From: Robert Findlay
Sent: 29 October 2008 10:05
To: Planning.Responses; Susan Leeson
Subject: FP 165/08 2 Admiralty road Felpham

Having seen the resubmission the following applies to some of the units.

**Proposed Ground Floor**  
Scale 1:50

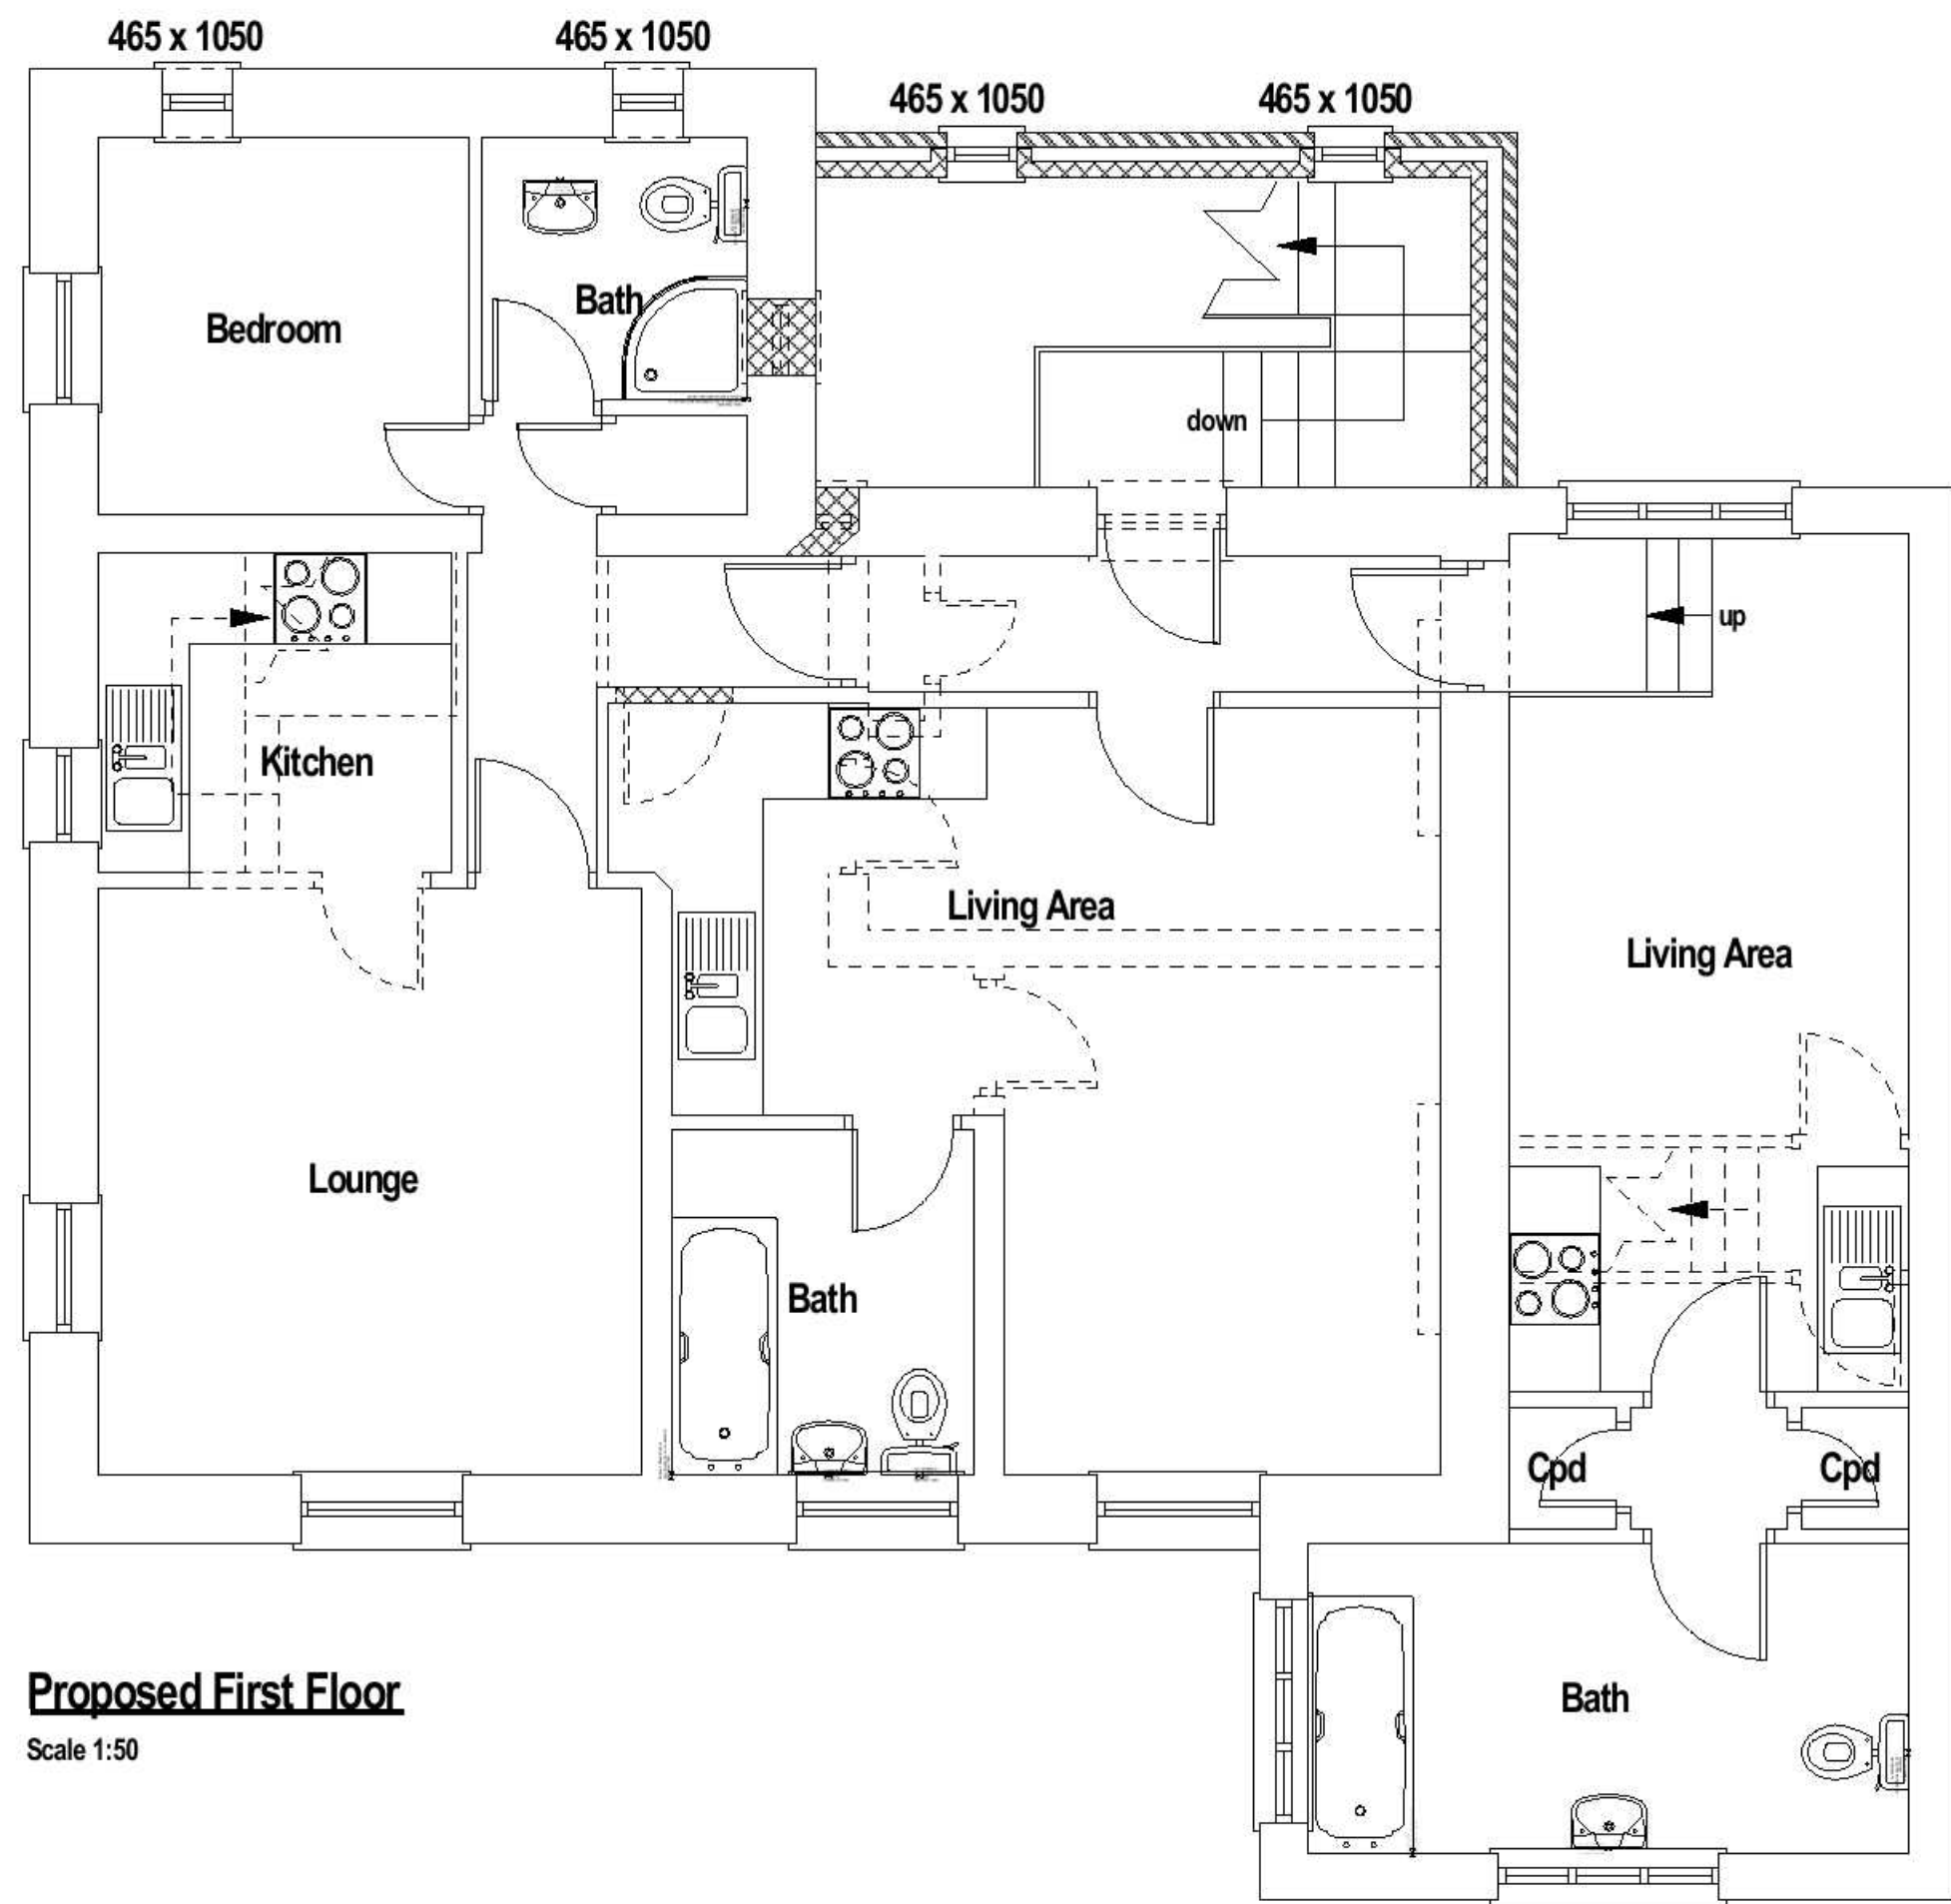
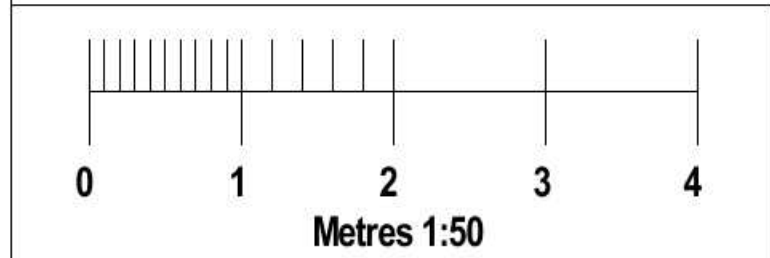
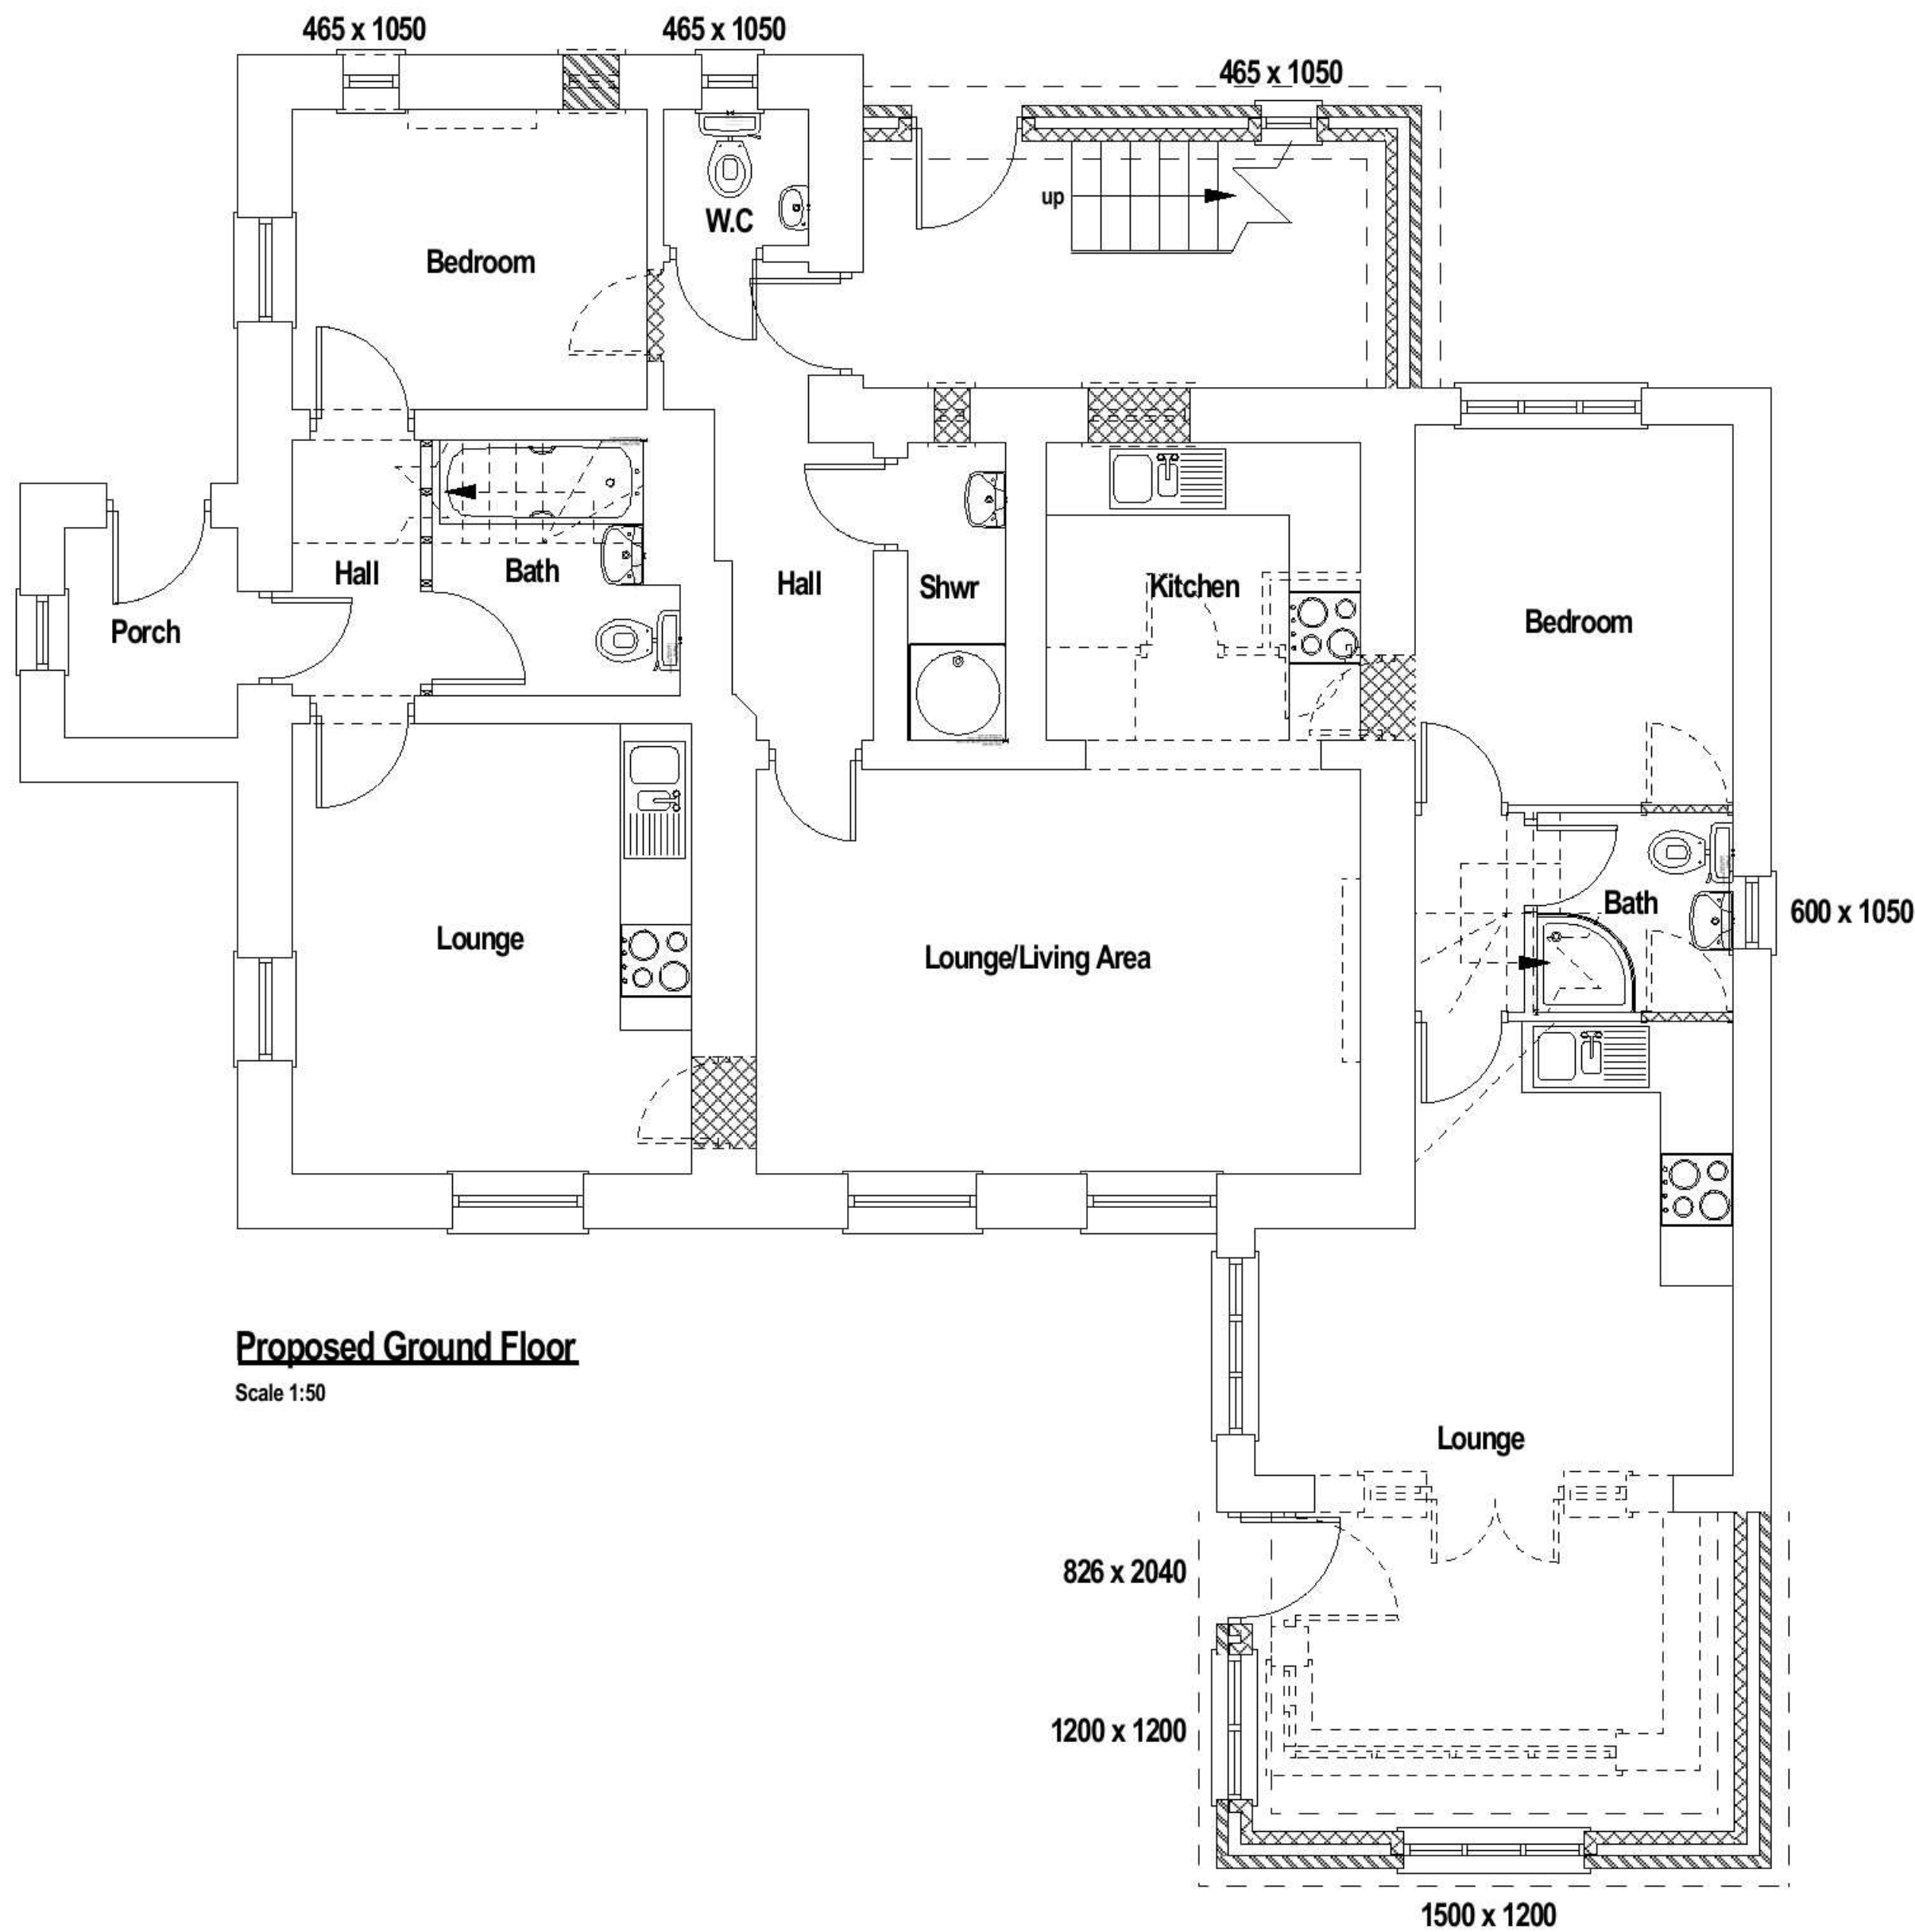
some of the units meet our standards but some do not meet the available floor areas specified below

The floor area for 1 bed roomed units with kitchen/ living room is to be as follows

bedroom size: 7sqm for 1 person or 10 m sq for 2 persons.

kitchen living rooms: 14.5 sqm.

Studio flats (shared living/bedroom/kitchens): the total available floor space is to be 19.5 sqm.

The available habitable floor area within the units proposed does not appear to allow for adequate circulation or separation of functions and there may be category 1 hazards created (as defined in the Housing Act 2004).

Should this development be allowed and the property are for the private rented sector / 'buy to rent' market then it is highly likely that should a housing health and safety rating system assessment be undertaken and category 1 hazards are highlighted especially in relation to crowding and space then this service may impose restrictions on the occupancy of the properties.

It is recommended the developer contact this office to discuss the proposal however I appreciate the developer may not know the future occupation of the premises and whilst the room sizes may be acceptable on a buy to occupy basis they are not on a buy to rent basis, based on current guidance for environmental health.
